Our Ref: BR/196/18/A
Your Ref:

Town & Country Planning (Control of Advertisement) (England) Regulations 2007 (as amended)
Application for Consent to Display an Advertisement(s)

Development Various illuminated & non-illuminated advertisements on various elevations.

Location The Co-op 152-156 Hawthorn Road Bognor Regis

001-088-103

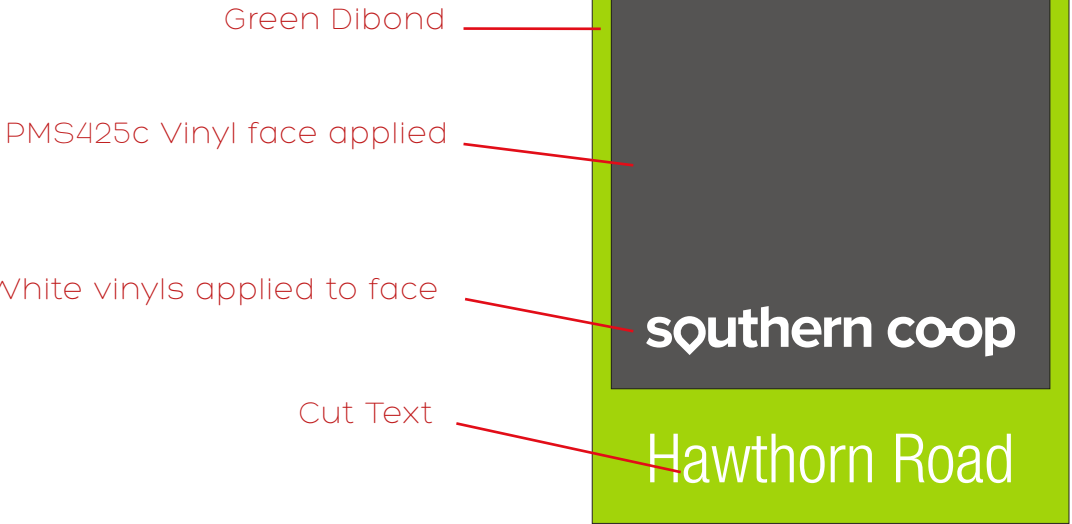
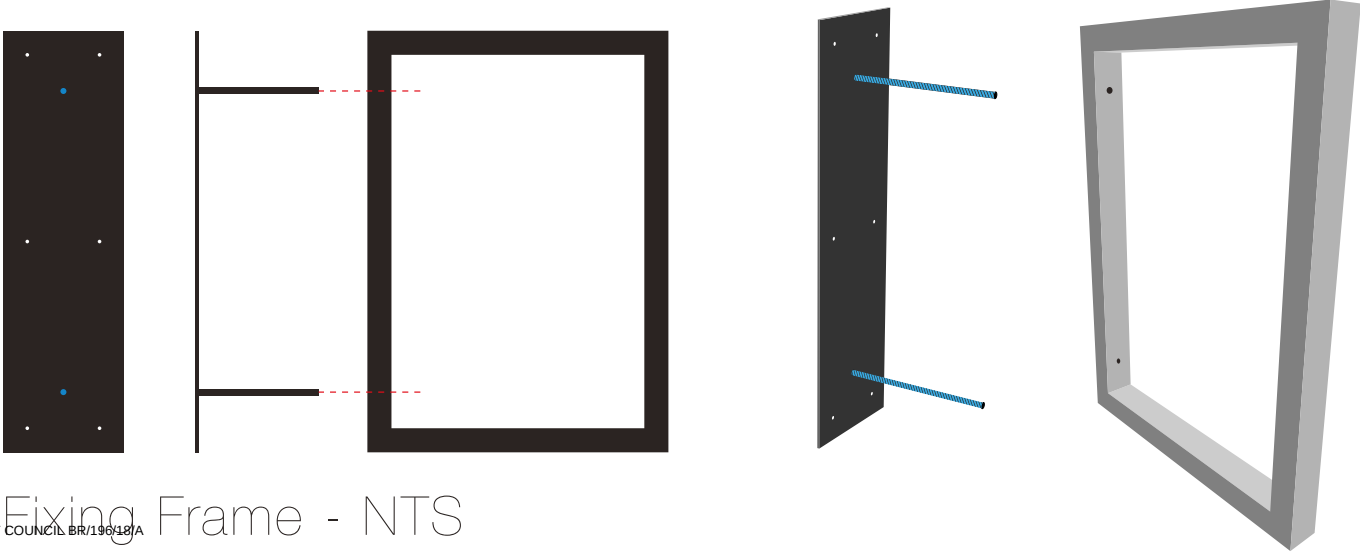
Please indicate if Fascia sign 2 is internally or externally illuminated.

DRAWING TITLE
LOCATION PLAN

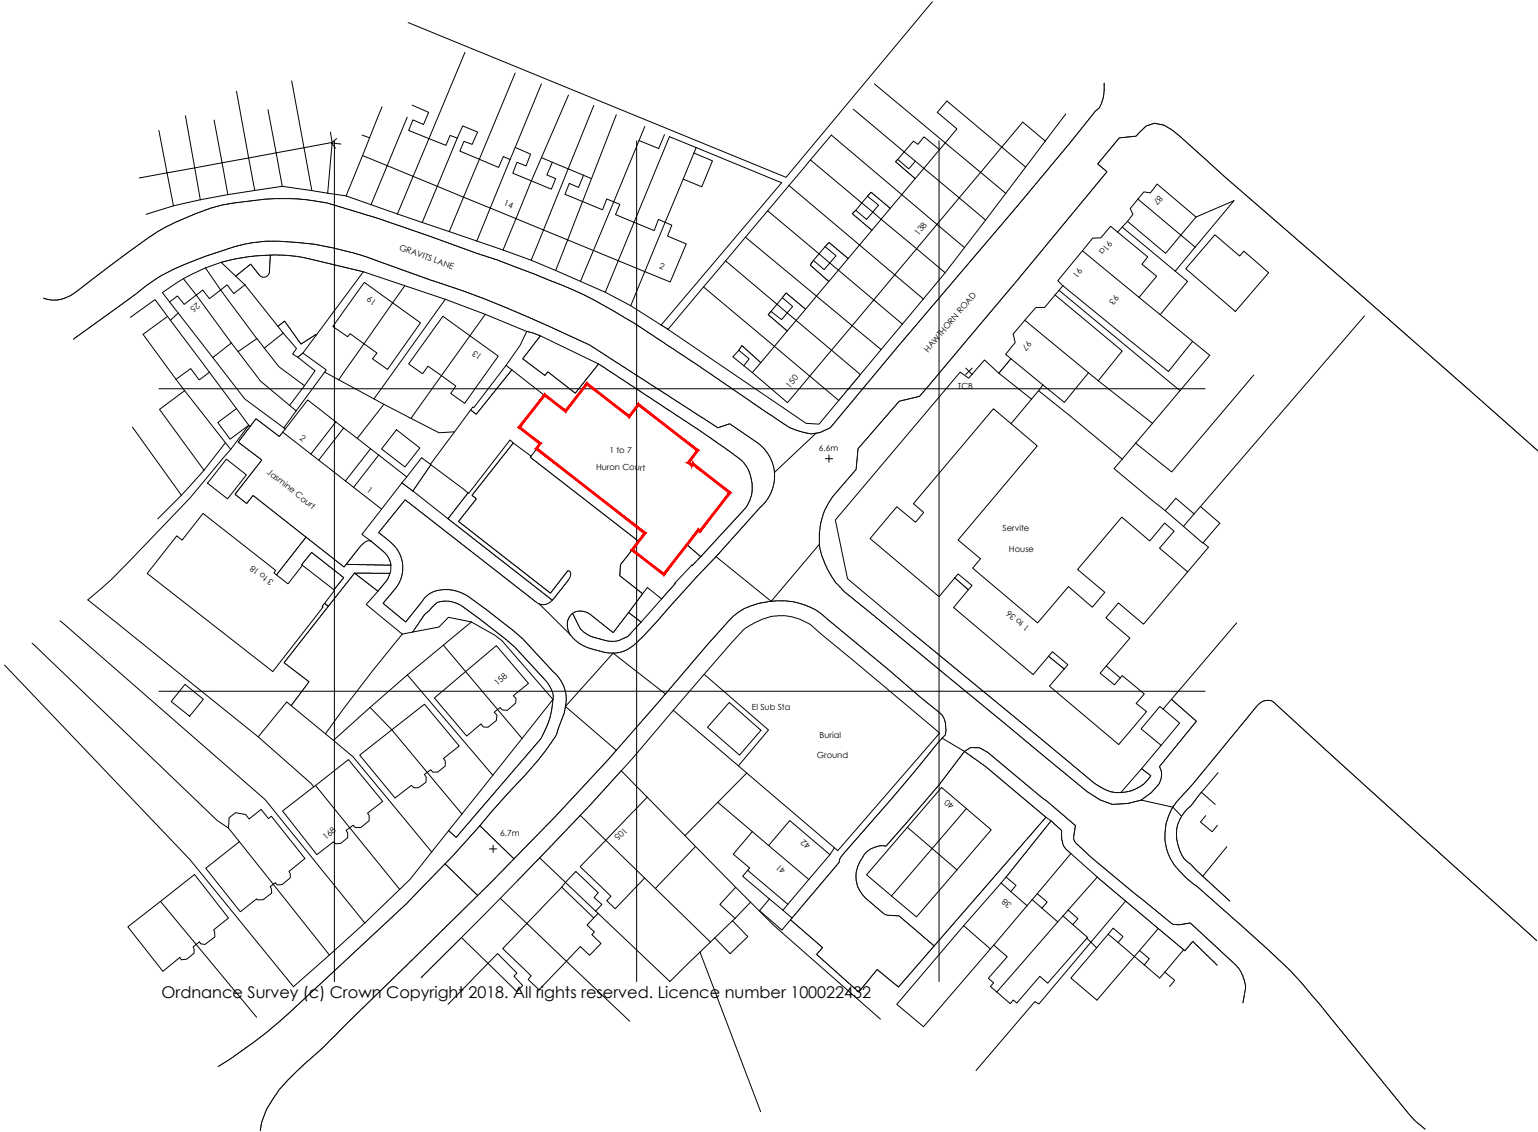
Location Plan Amend

The location plan that was submitted does not appear to be in the Arun District. Please provide a location plan that shows the site and surrounding properties, with the application site edged in red, two named roads, a north point, a scale and annotate the position of the proposed advertisements.
